FROM: Chris McDonald – Email: Chris@developingsvcs.com

RE: City of Mercer Island (CoMI)- Summary response to 2209-287-SUB1-PLANS_review-1.pdf

SHEET/TITLE  
(E) UTILITIES  
C0.1

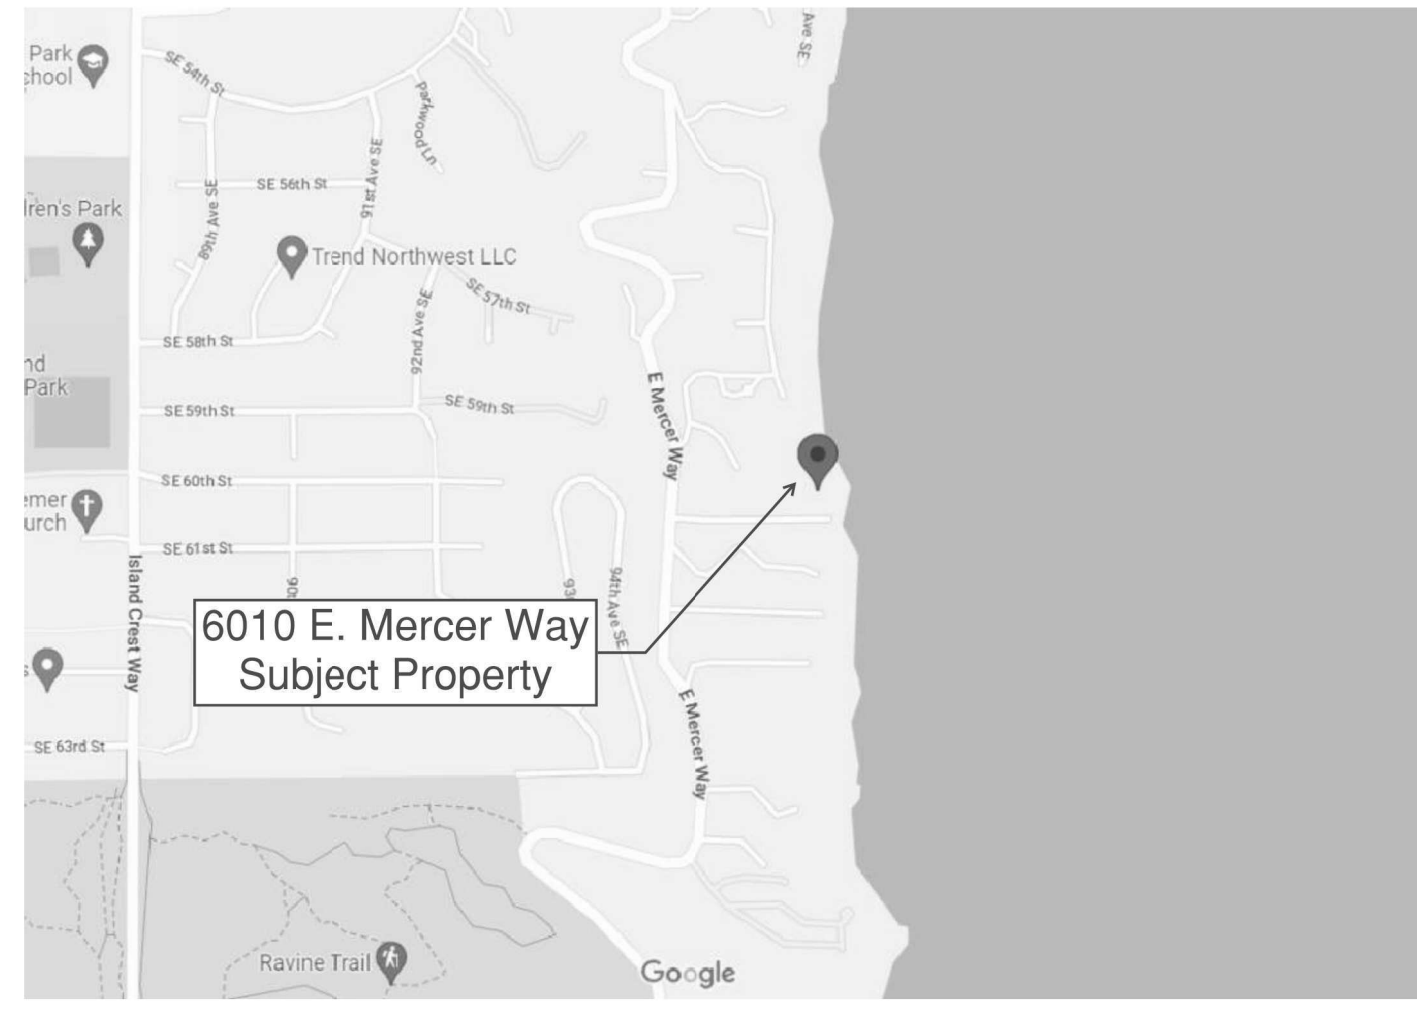
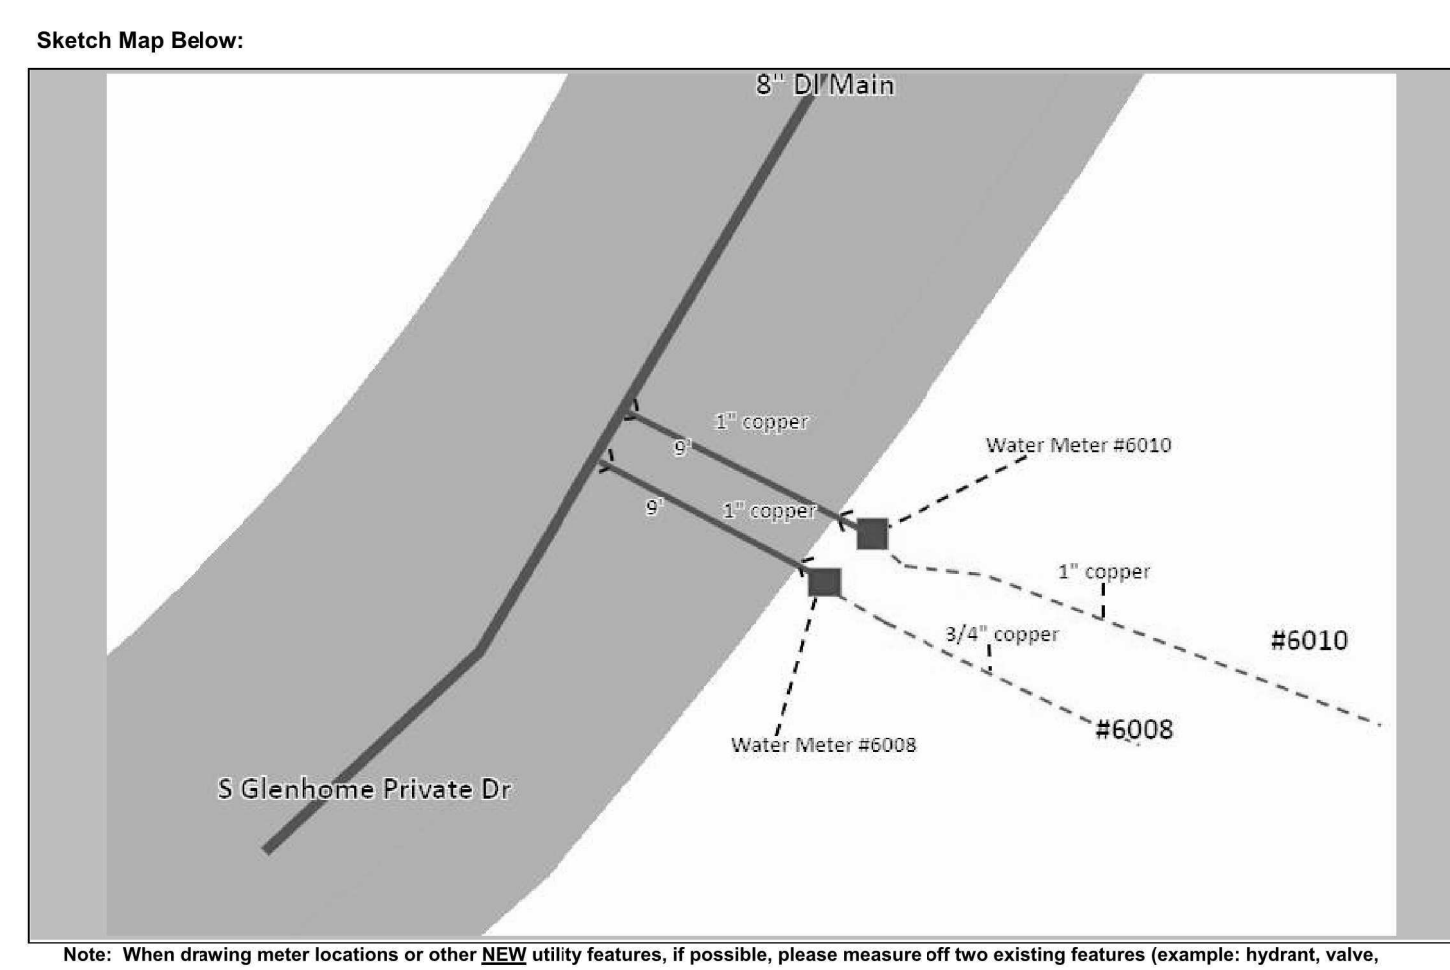
This site requires a 1" water meter upsize, 1.5" water supply line upsize (from meter to building) and a reduced pressure backflow assembly (RPBA)...

In coordination with Don Cole at the CoMI, we have run a hydraulic analysis, in the effort to try and avoid the waterline upsize/replacement due to the significant ECA impacts it would create. Instead, we ran the analysis of the original 1" copper line based on the site conditions, and were able to fall within suitable parameters while only upsizing the meter to a 1", and keeping the existing 1" copper service from the meter to the home, and installing a 1" RPBA at the location shown on the attached plans. This RPBA to be installed / inspected by a someone licensed to perform this work in the city, and in accordance with attached hydraulic analysis, and per C2.0 of the attached plans, including either a Hotbox or heat trace, or below grade methods to avoid freezing. Additionally, the existing easement is reflected within the plan sheets, although no work will be required outside of the CoMI water dept upsizing the meter/setter from the 5/8 (3/4") meter that the City replaced back in 2018, to a 1" meter/setter. Both supply and service lines to remain as installed (1" copper).

The analysis is acceptable. Please go ahead and submit formally for approval.

**(E) SEWER**

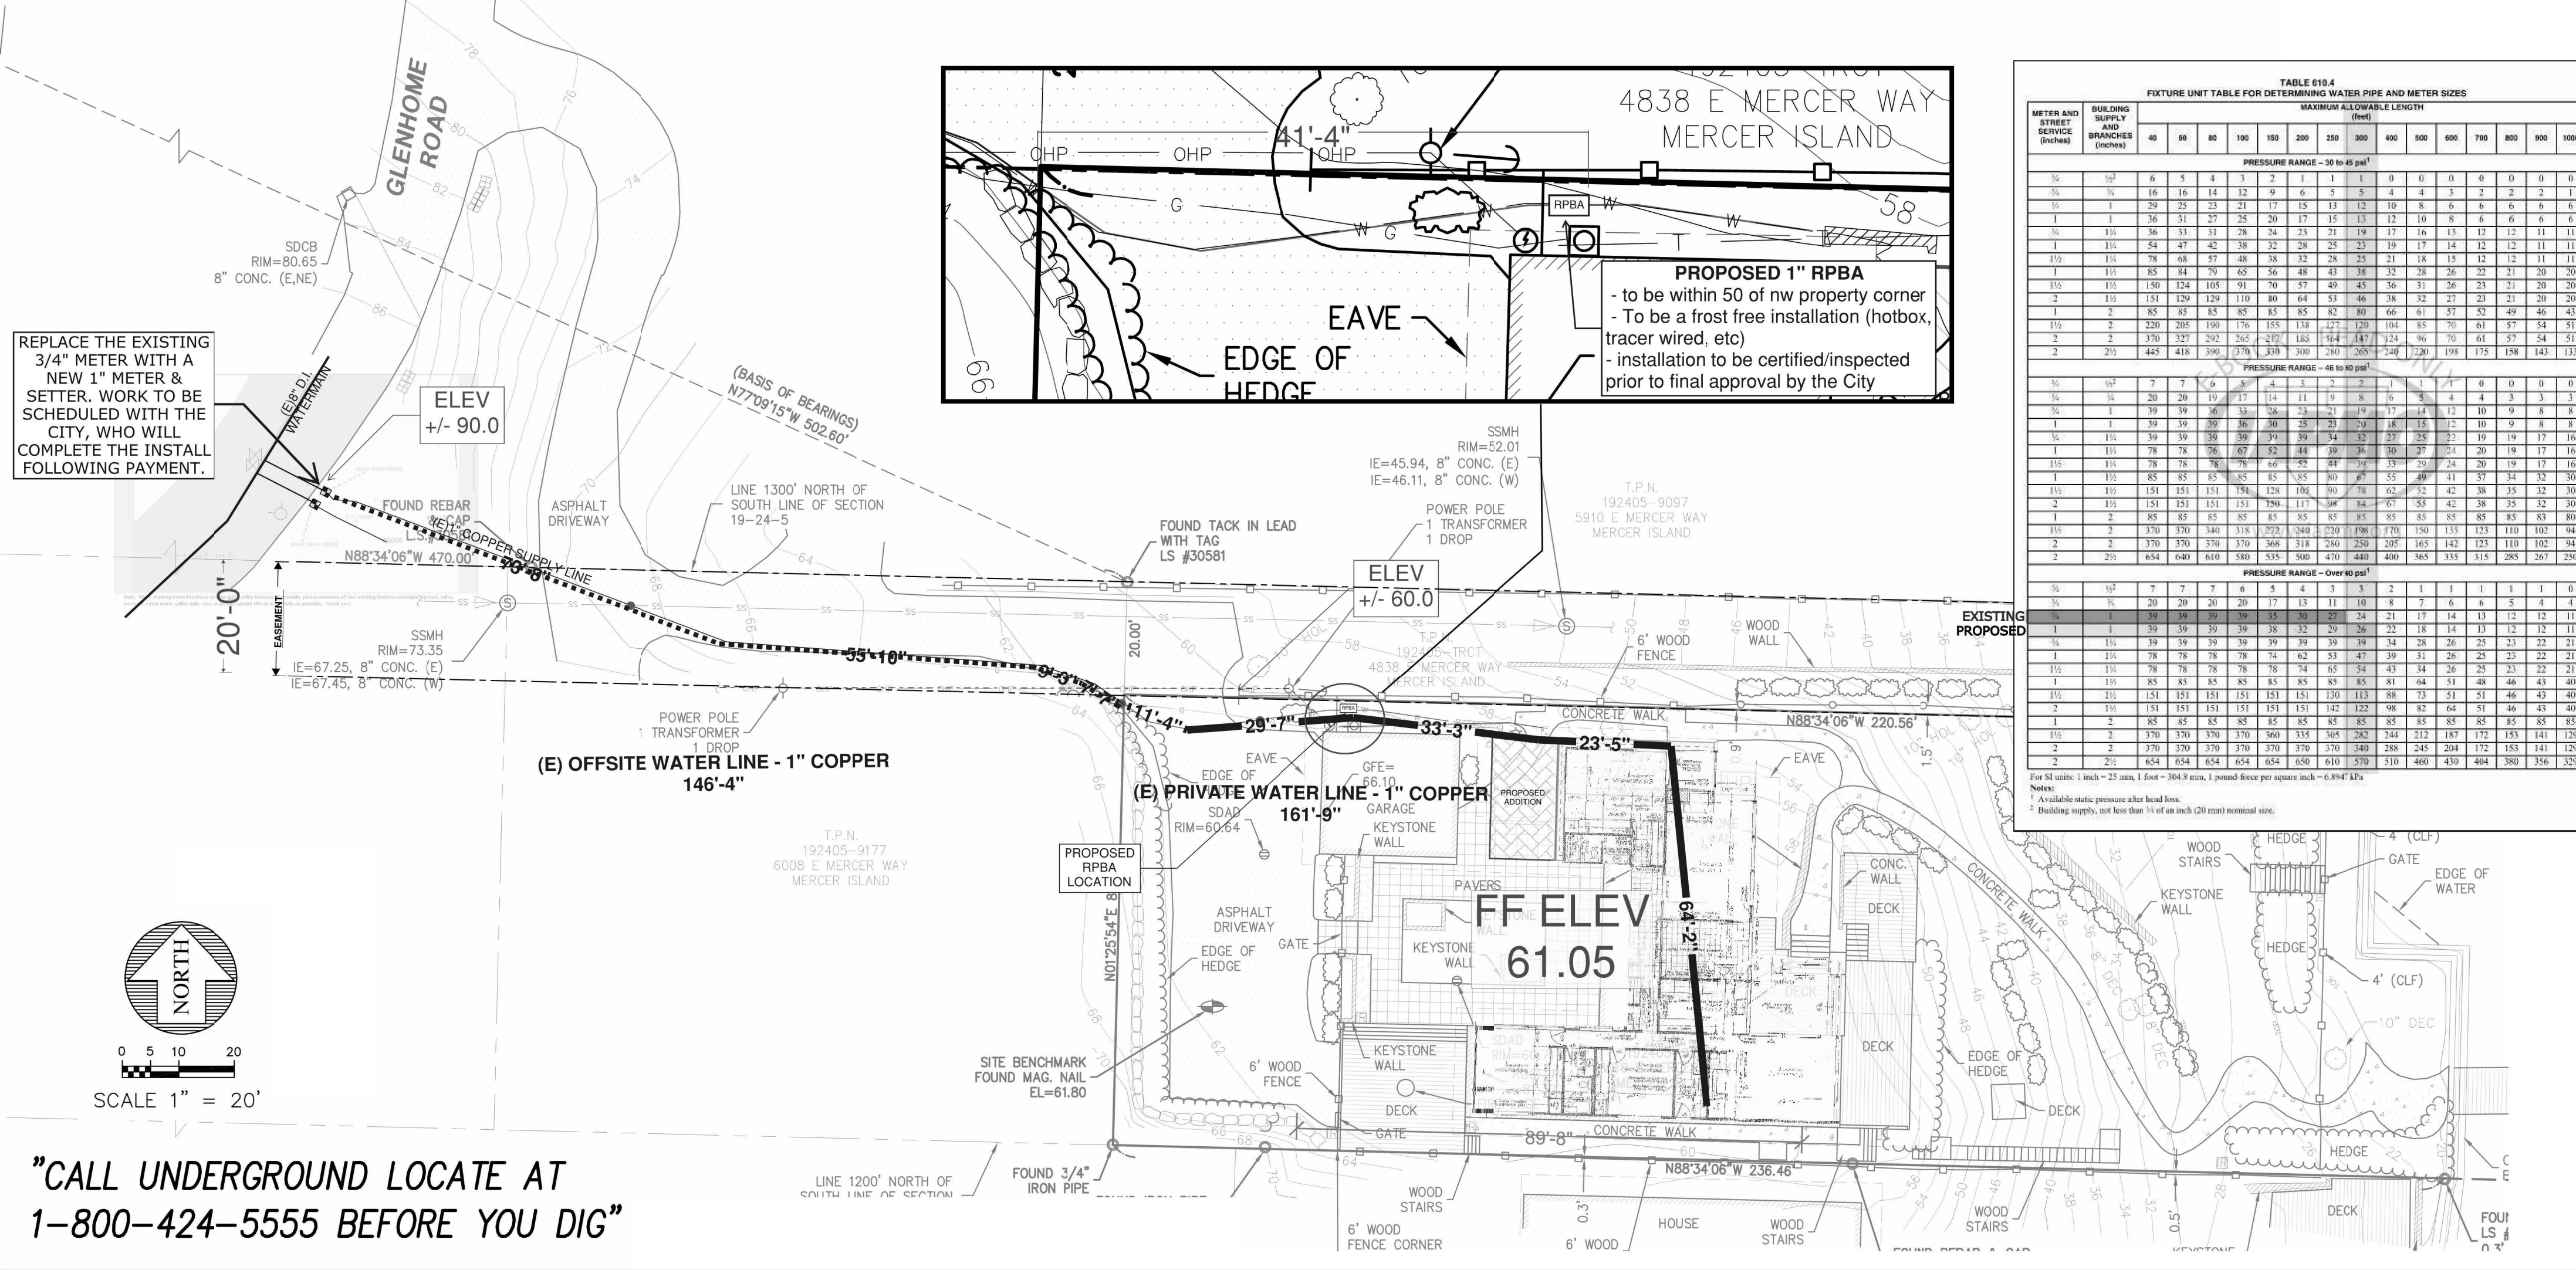
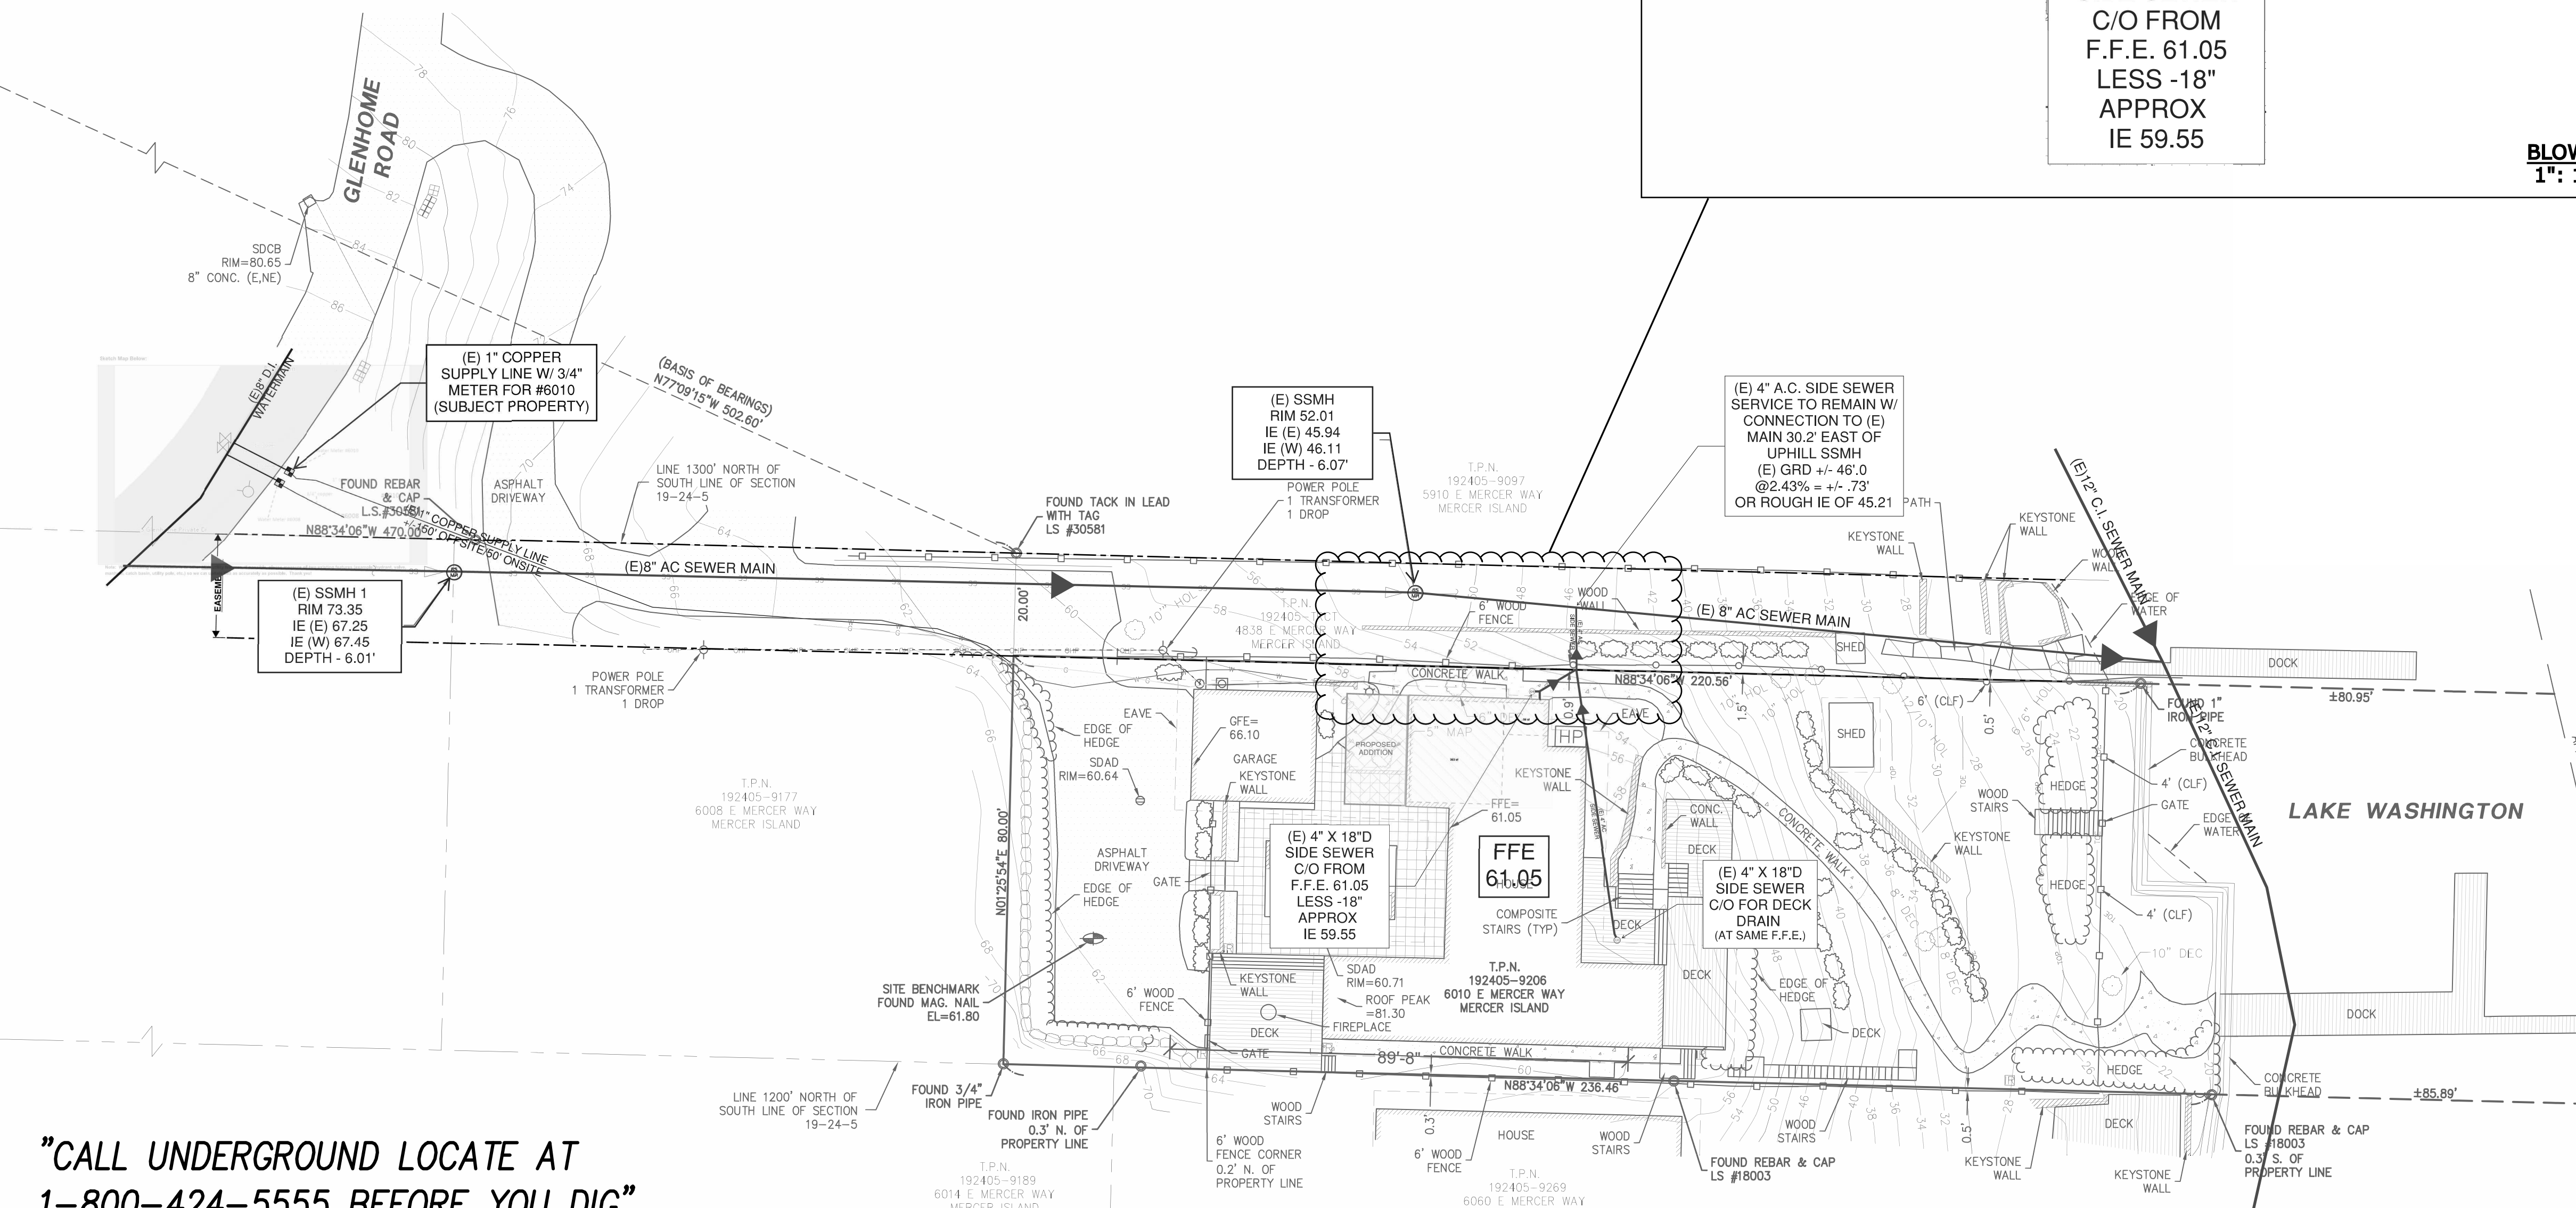
The site must have a sewer backflow prevention valve installed for the building, refer to the sewer standard details S-23 through S-26 for more information.

Details S-23 to S-26 make specific reference to “... *direct* side sewer connections from a residence to the Lake Line” only. This does not apply to our side sewer which, actually connects to a public main in an easement north of the property, and *that* public main connects to the Lake Line. Subsequent conversations between Kevin and I (**Chris McDonald**) concluded as much, and that the only concerns were that we confirm the lowest fixture on the side sewer connection from the home, is higher than the next upstream manhole. The below info is reflected on the sewer plan, and from either survey or As-Built data on record, and summarized below:

Upstream manhole info:

Rim 52.01
IE (E) 45.94
IE (W) 46.11

Existing SFR/SIDE Sewer:

SS Tap IE at public main	+/- 45.21
C/O IE at entrance to SFR	59.55 (18” below F.F./GRADE)
SFR main finish floor elevation	61.05 (+/- 15’ above low IE of upstream manhole)

All waste from the SFR is from 2 bathrooms on the main level, and a 3rd bath, in the addition on the south side of the home, which stacks with the 2nd bath. Below the main level is unhabitable space used for storage/ductwork/etc and contains no known plumbing, of which would require pumps/forcemain lines up to the waste line where it enters the SFR shown on the plan sheets
